16th February 2024

RE: Planning Application under Section 73 of the Town and Country Planning Act (1990) to vary condition 2 pursuant to Planning Permission ref: 2023/0195 for Residential development of 95no. dwellings (Amended Plans) at Land North of Barnburgh Lane, Goldthorpe.

nineteen47 is instructed on behalf of Homes by honey [the "Applicants"] to submit a planning application under Section 73 of the Town and Country Planning Act to vary Condition 2 pursuant to Planning Permission ref: 2023/0195.

Project Code	Drawing Nr	Rev	Drawing Scale
n1982	700	E	1:500 @ A1

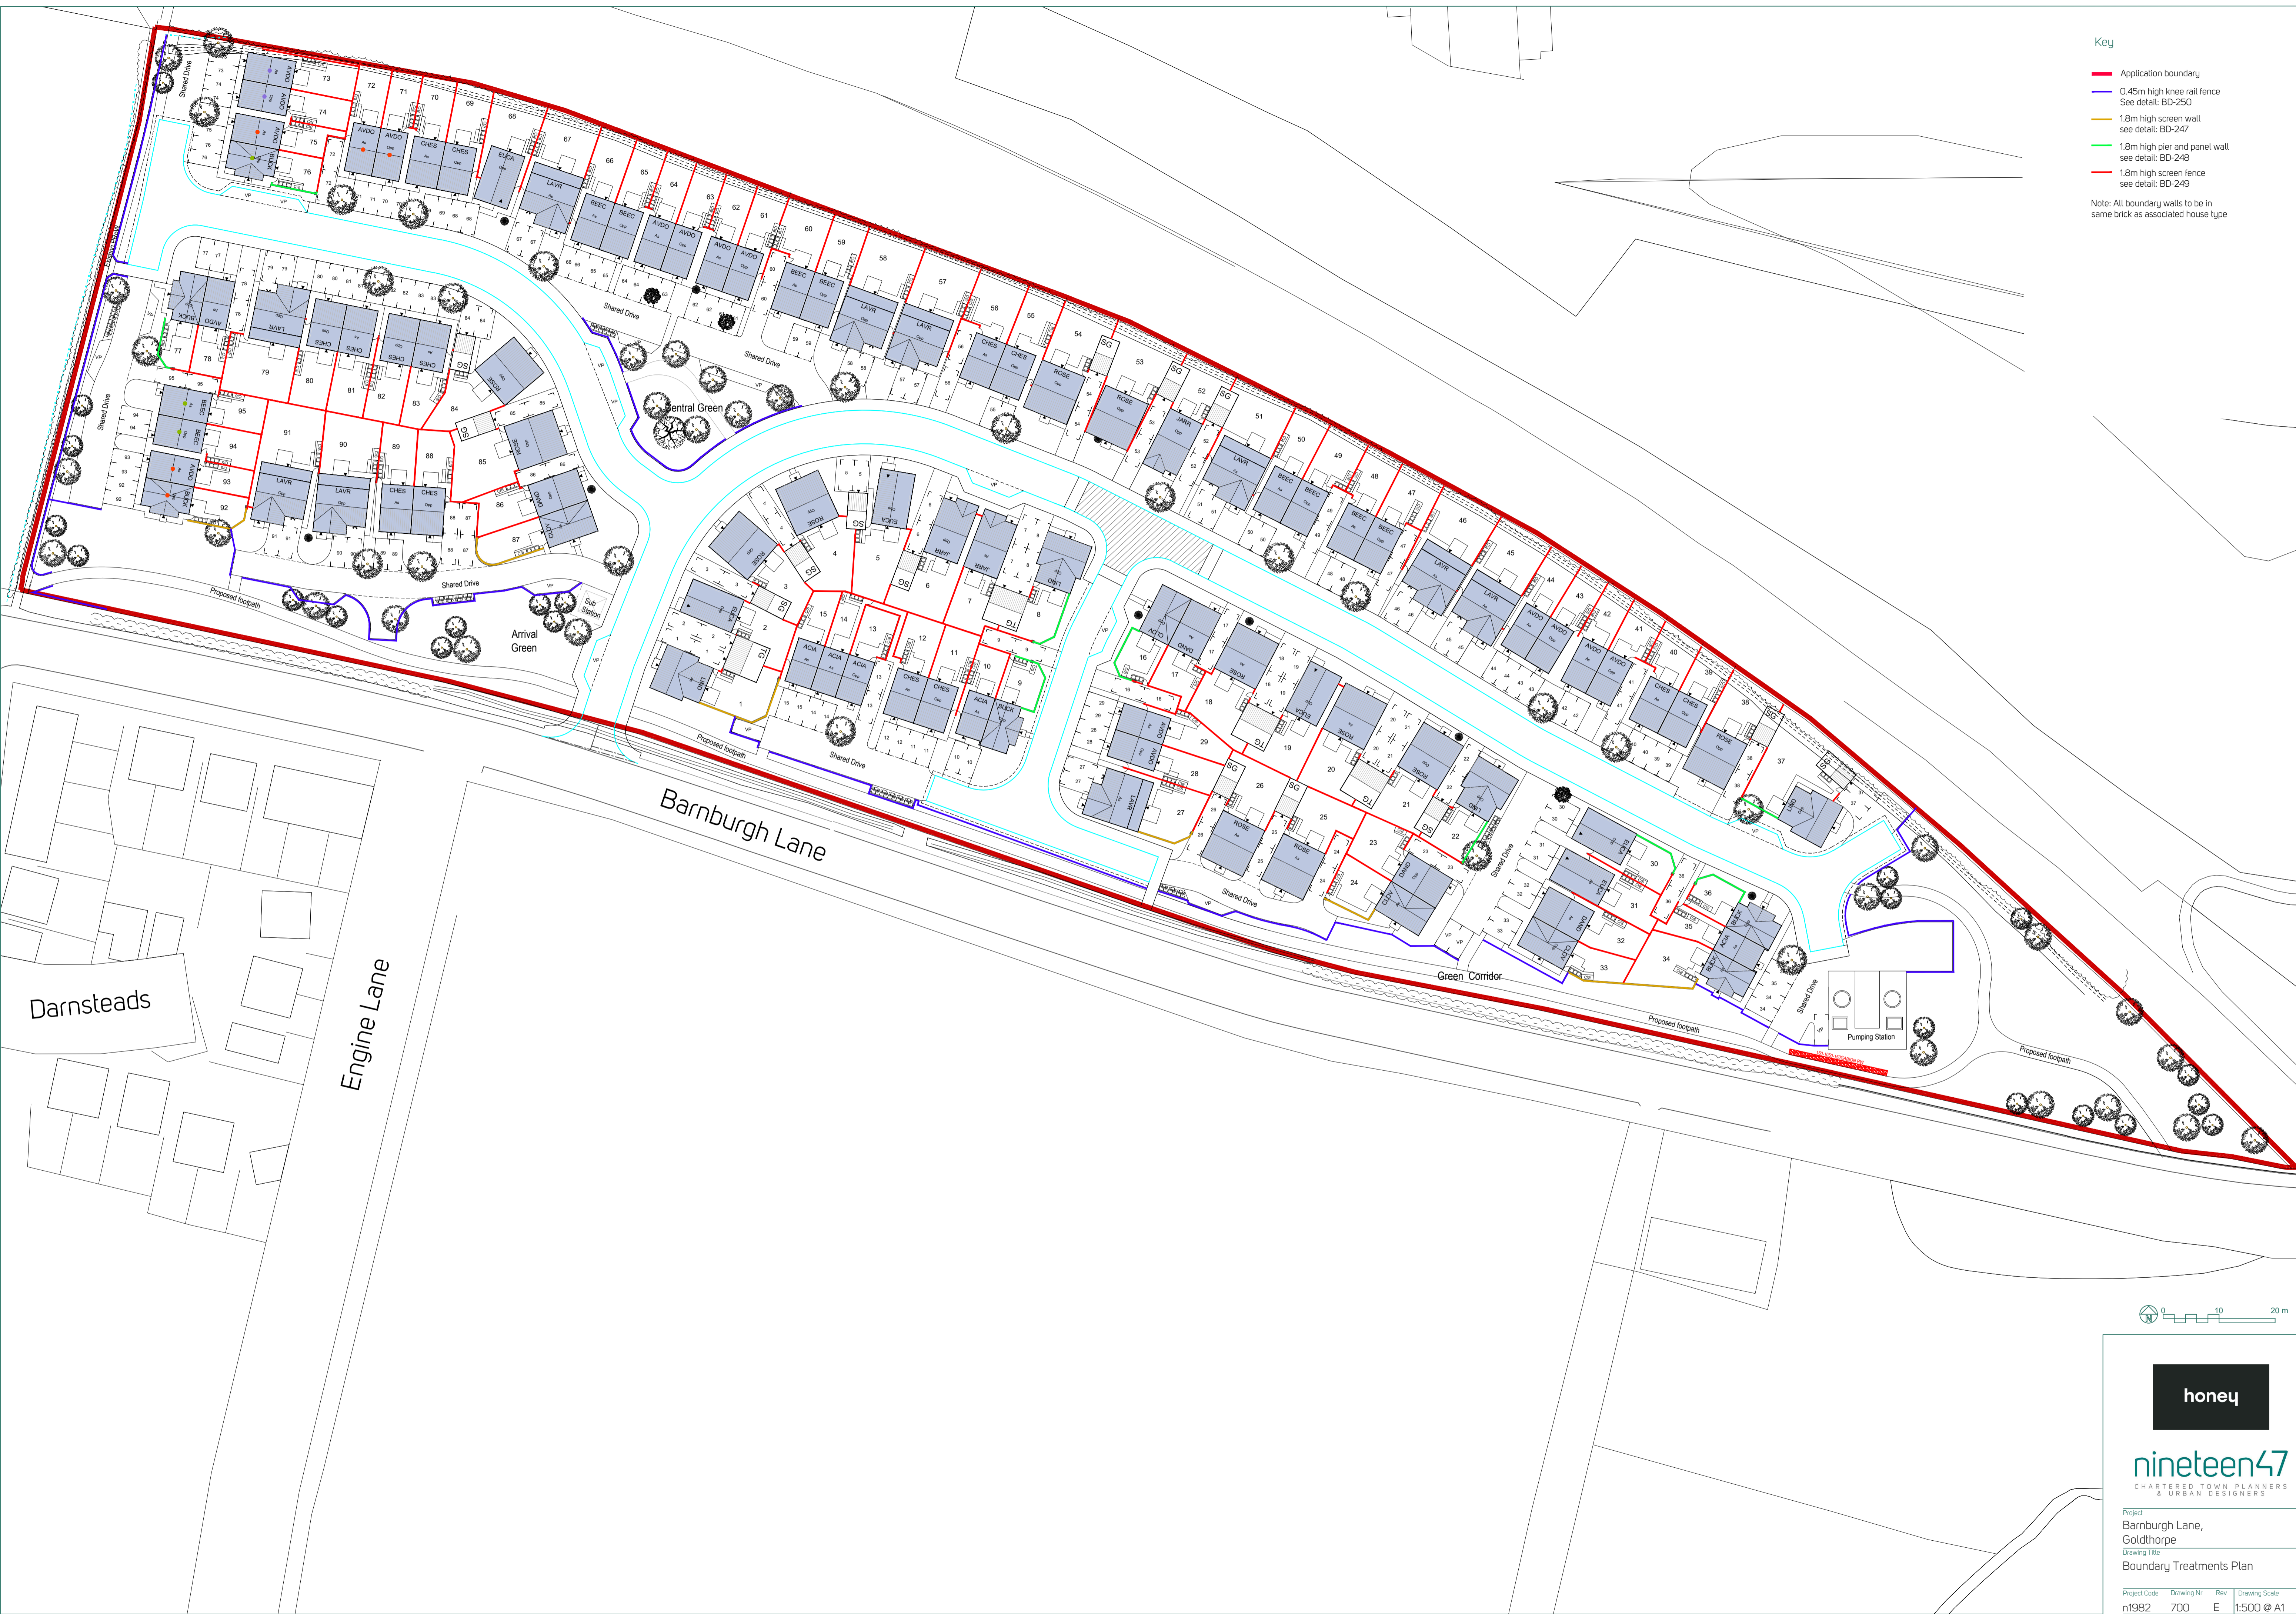
- *Planning layout – 008 Rev F*
- *Soft Landscape Proposals GL204701B*
- *Soft Landscape Proposals GL204702B*
- **Boundary Treatment Plan 700 Rev B**
- **Garden Areas Plan 101 Rev B**

- *Planning Layout – 008 REV M*
- *Soft Landscape Proposals GL204701G*
- *Soft Landscape Proposals GL204702G*
- *Boundary Treatment Plan 700 Rev G*
- *Garden Areas Plan 101 Rev E*
